From: [David O'Connell](#)
To: [Michelle Niles](#)
Subject: RE: Notice of Modification Request - Casuarina Town Centre Project Approval (MP 06_0258 MOD 12)
Date: Tuesday, 11 December 2018 3:55:01 PM
Attachments: [image007.png](#)
[image008.jpg](#)
[image009.jpg](#)
[image010.png](#)
[image011.jpg](#)
[image012.jpg](#)
[image013.png](#)
[image014.jpg](#)

The proposal seeks to separate a medium density lot into two lots. Proposed lot 1 is an existing car park and proposed lot 2 is an existing multi dwelling development. A request for information was sent to the applicant (via Department of Planning) demonstrate that by separating the medium density lot into two lots that each lot can be adequately serviced for any future dwelling construction. In particular proposed Lot 1 as this lot only has an existing car park and is not serviced (note there has been numerous queries to provide a dwelling on the existing car park area).

Water & Wastewater has reviewed the Further Information details provided by Planit Consulting regarding the mod to subdivide the existing carpark lot from the existing lot parcel.

Figure 3 | Alternative Sewer Connection Locations

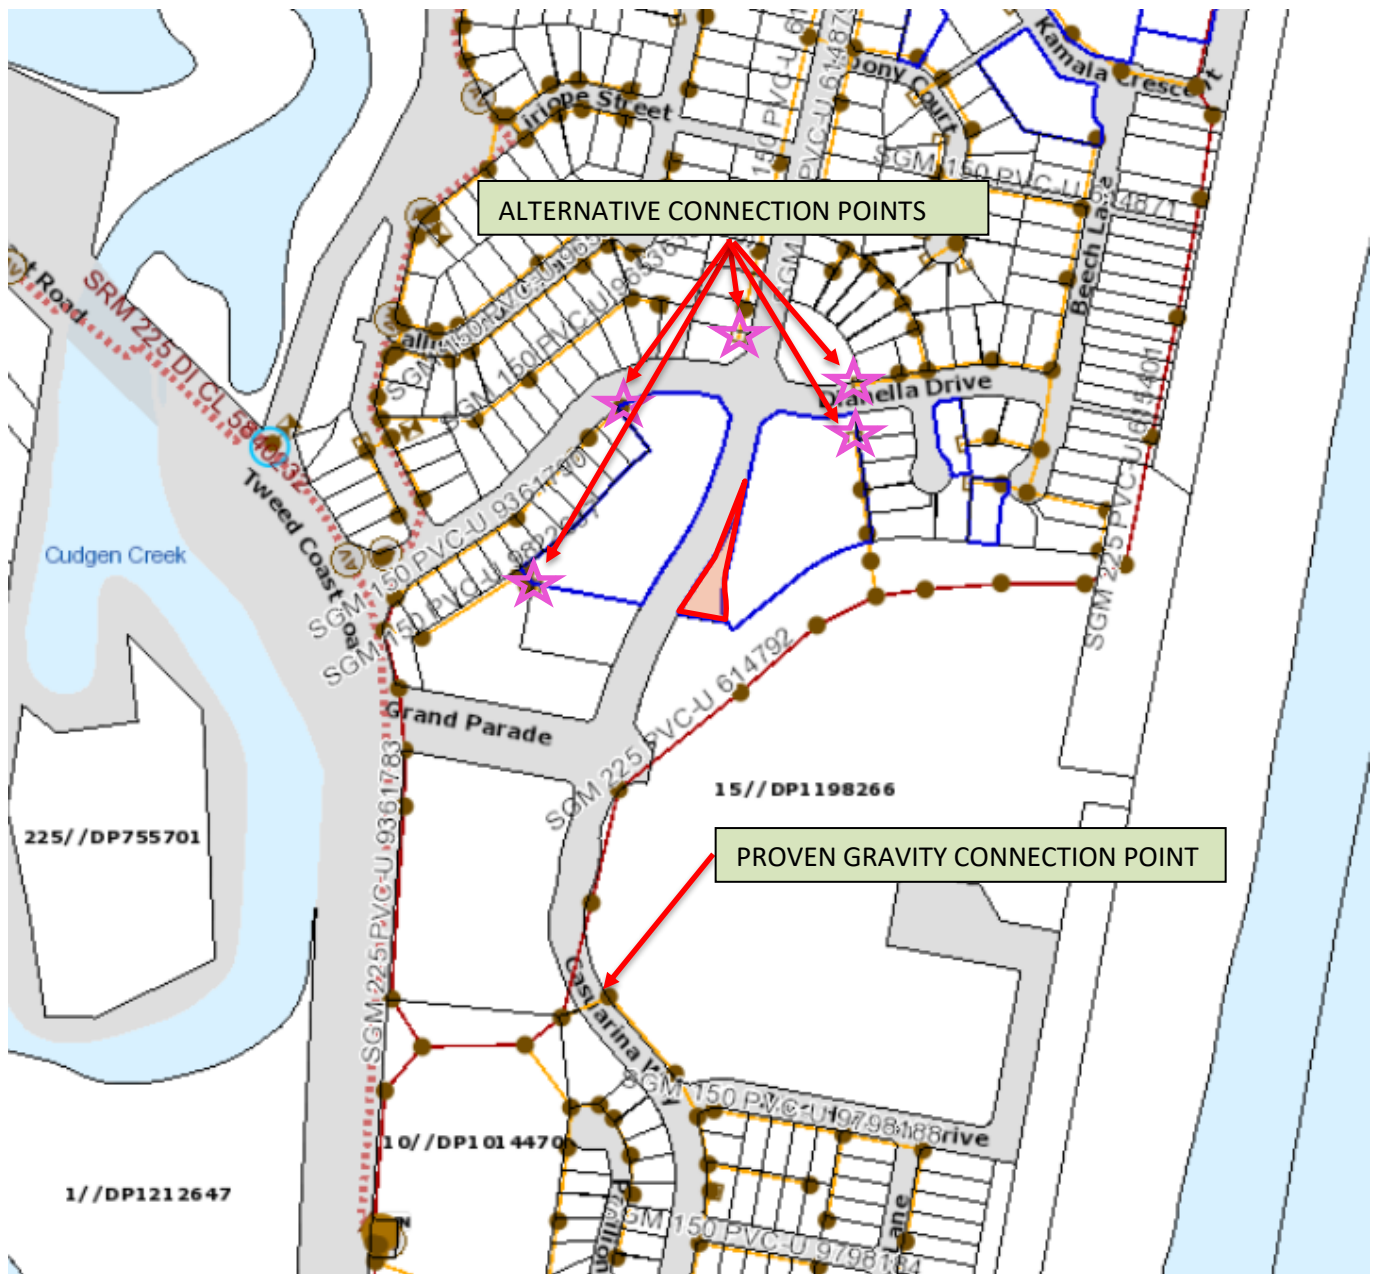
- 2) The application does not demonstrate how the car parking lot can be adequately serviced by sewer....demonstrate connection point and gradients.

The applicant has updated the information and recommended that the lot connect to the sewer proposed to the south of the lot, however has made no effort to confirm how the works would be undertaken or how owners consent for easements across private property would be obtained.

| DRAWING TITLE:<br>SERVICES CONNECTIONS |                      |                         |                      |           |

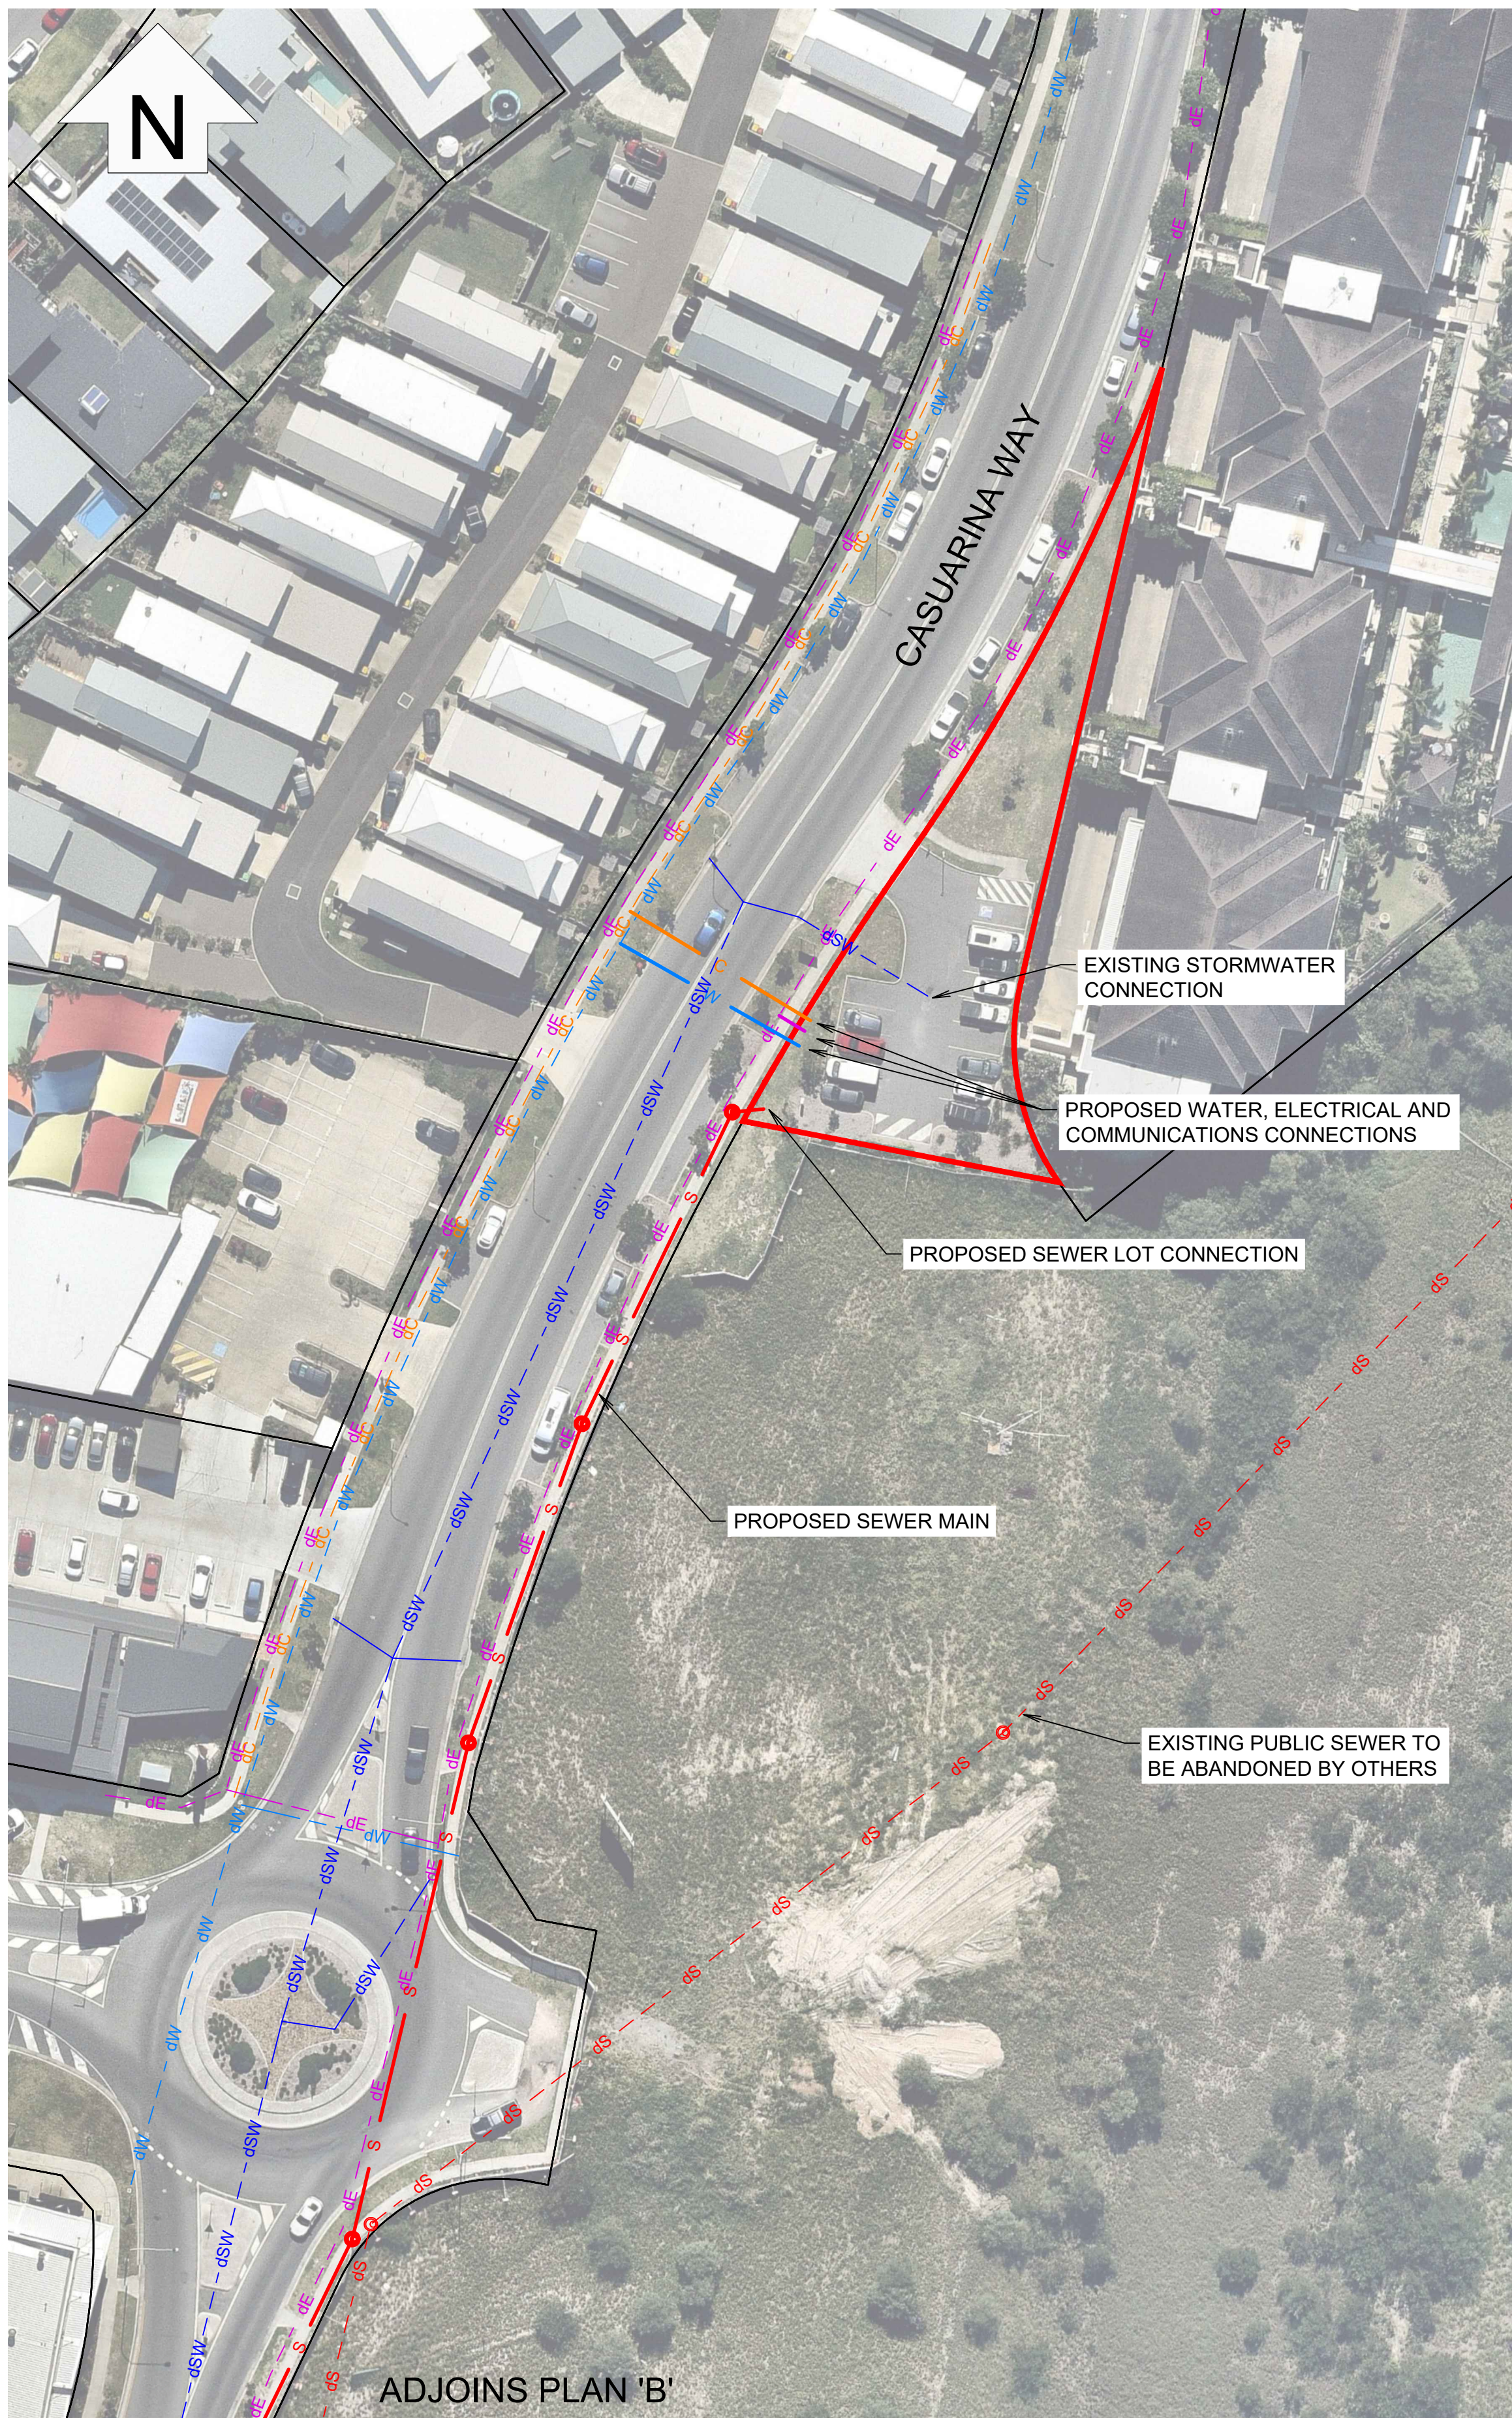
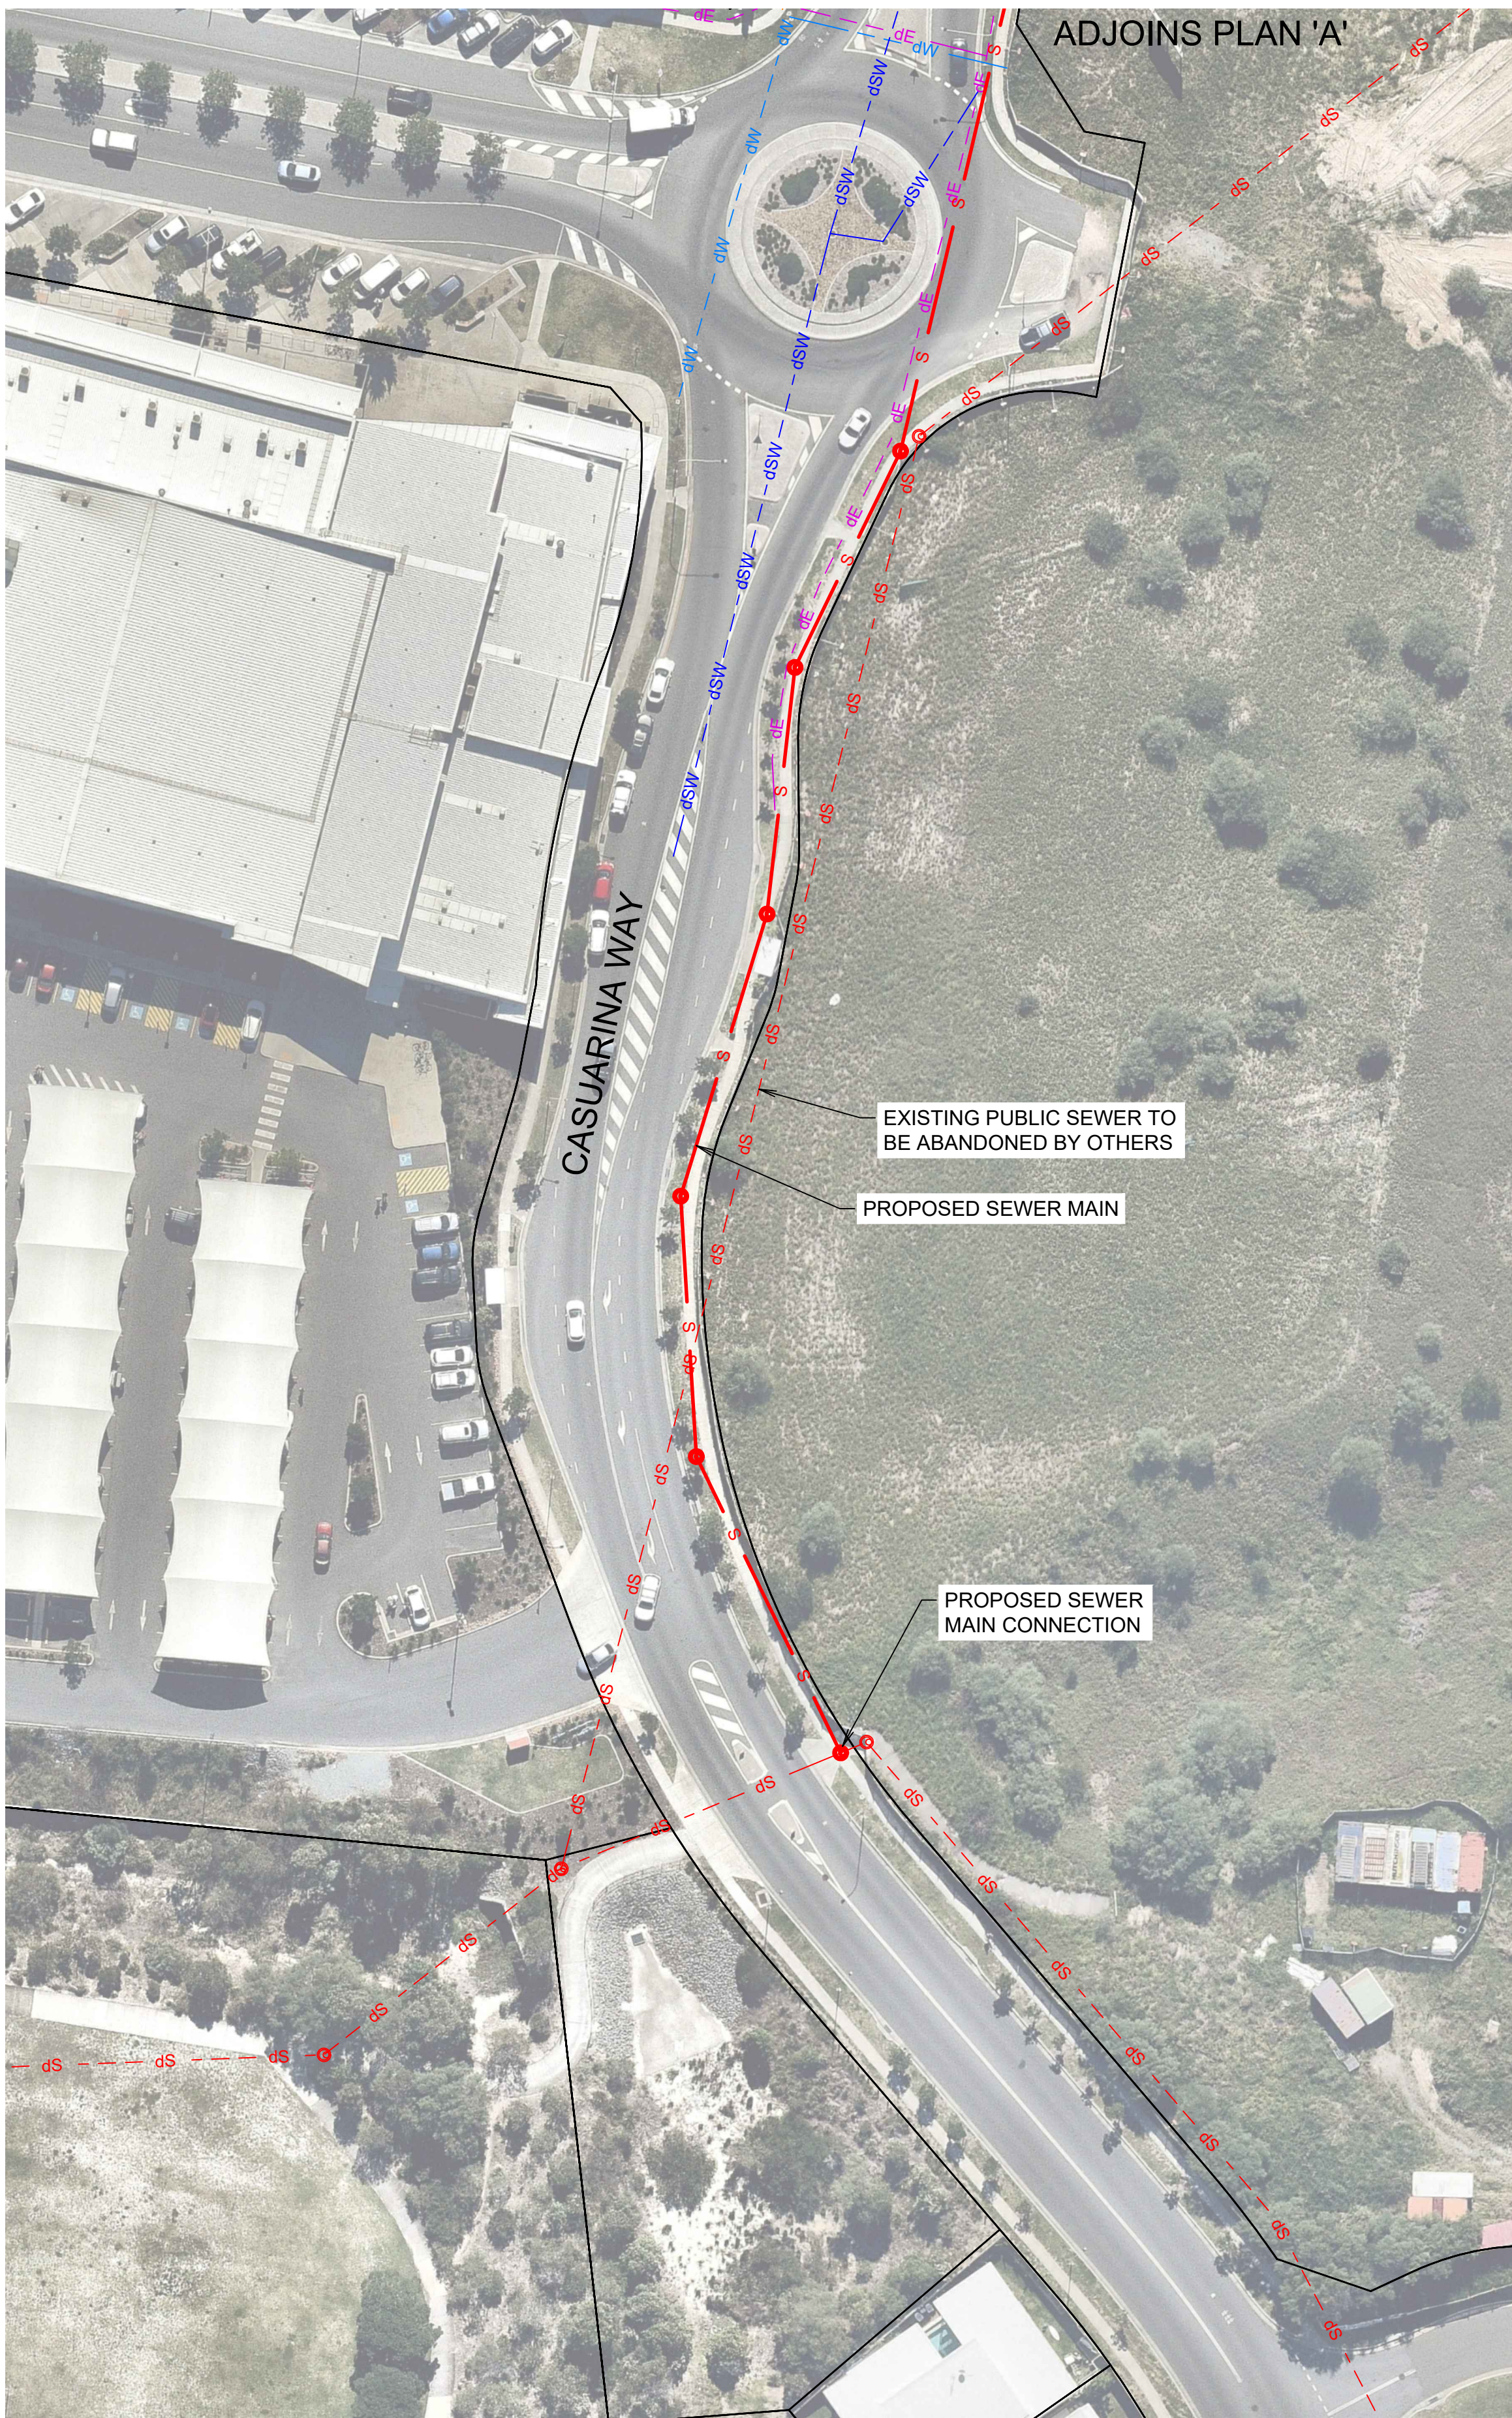
- 1) In order for proposed lot 1 to be serviced by sewer the proposal seeks to extend through private property. It is most likely that an easement will be required over future Lot 51 to service proposed Lot 1. Hence, the proposal is relying on extending a sewer line within private property (creation of an easement). No owners consent has been provided for sewer in private property.

The proposed two lot subdivision is not supported as the applicant has not demonstrated that the lot can be adequately serviced for sewerage. It is recommended that the application be withdrawn, or further information provided to demonstrate how the services can be provided as part of the currently proposed civil construction works proposed for Casuarina Town Centre.
